# EL PASO COUNTY PLANNING AND COMMUNITY DEVELOPMENT DEPARTMENT

## GRADING AND EROSION CONTROL PLAN CHECKLIST Monument Small Engine Storage ( PPR1946 ) 10/24/19

GRADING PLAN

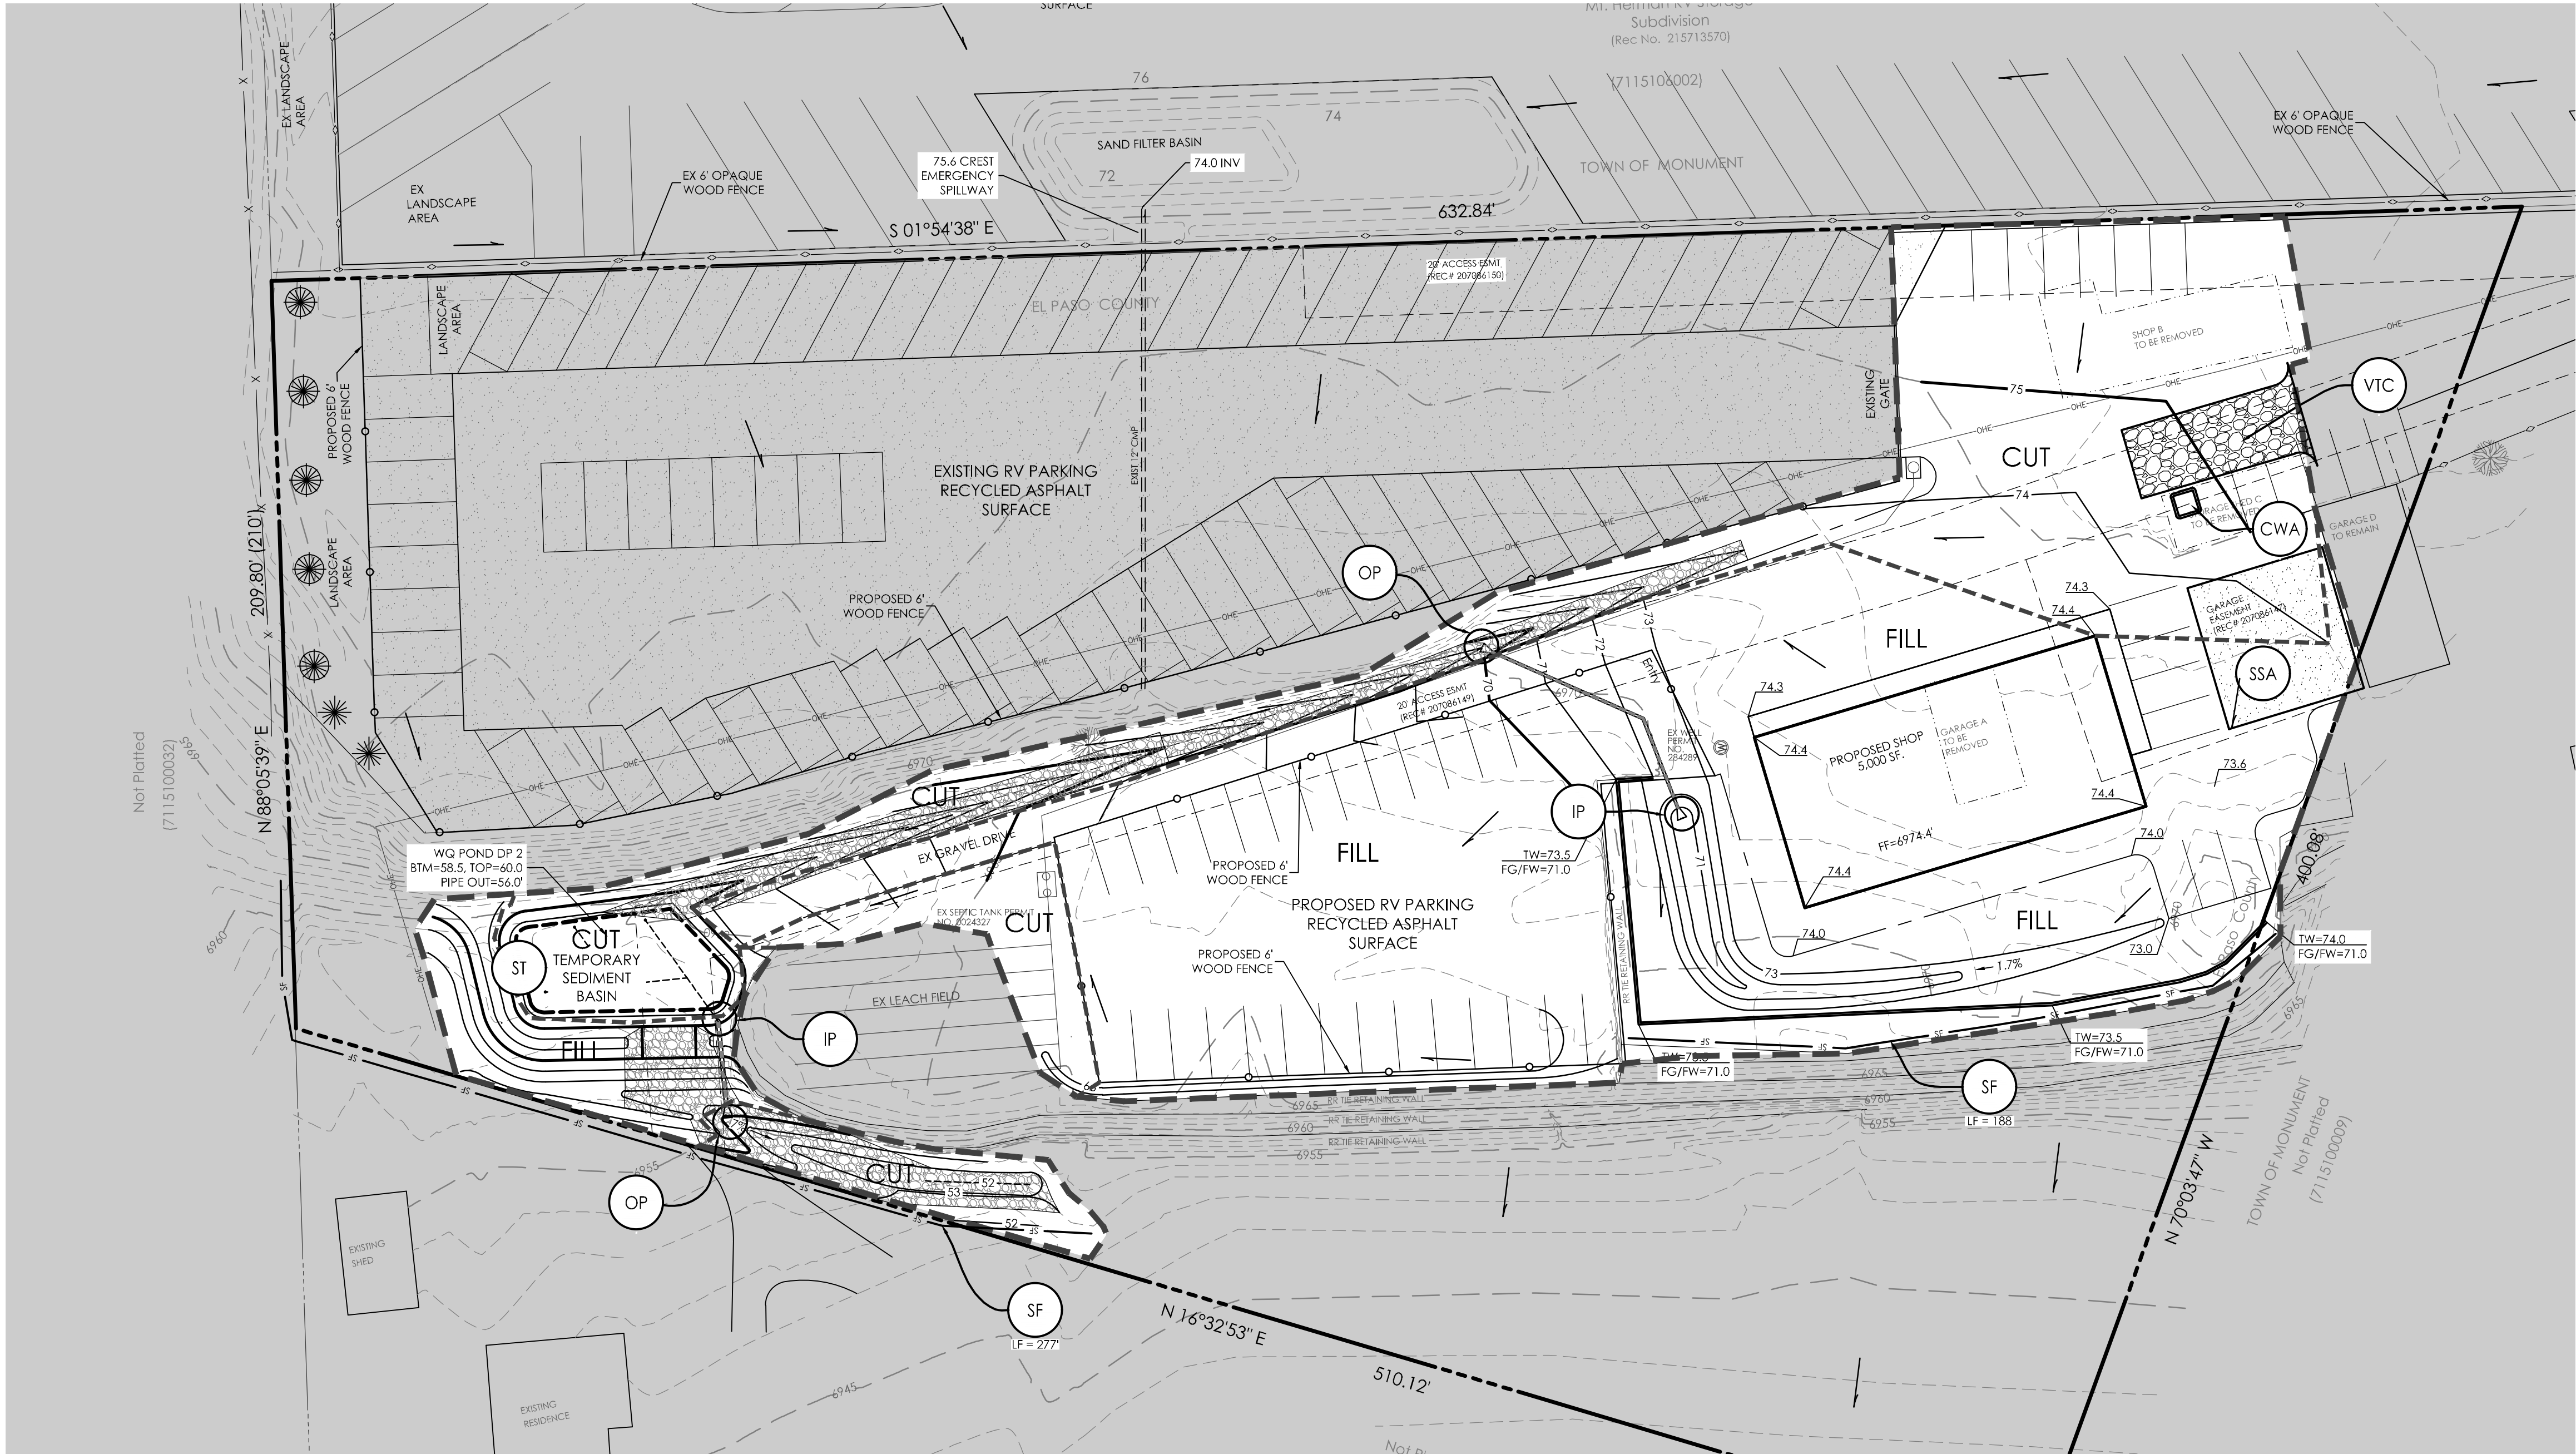
v	All proposed temporary construction control measures, structural and non-structural. Temporary construction control measures shall be identified by phase of implementation to include "initial," "interim," and "final" or shown on separate phased maps identifying each phase.	Y	✗
w	Vehicle tracking provided at all construction entrances/exits. Construction fencing, barricades, and/or signage provided at access points not to be used for construction.	Y	✓
x	Temporary sediment ponds provided for disturbed drainage areas greater than 1 acre.	Y	✓
y	Dewatering operations to include locations of diversion, pump and discharge(s) as anticipated at time of design.	N/A	✓
z	All proposed temporary construction control measure details. Custom or other jurisdiction's details used must meet or exceed EPC standards.	Y	✓

Missing from the plans
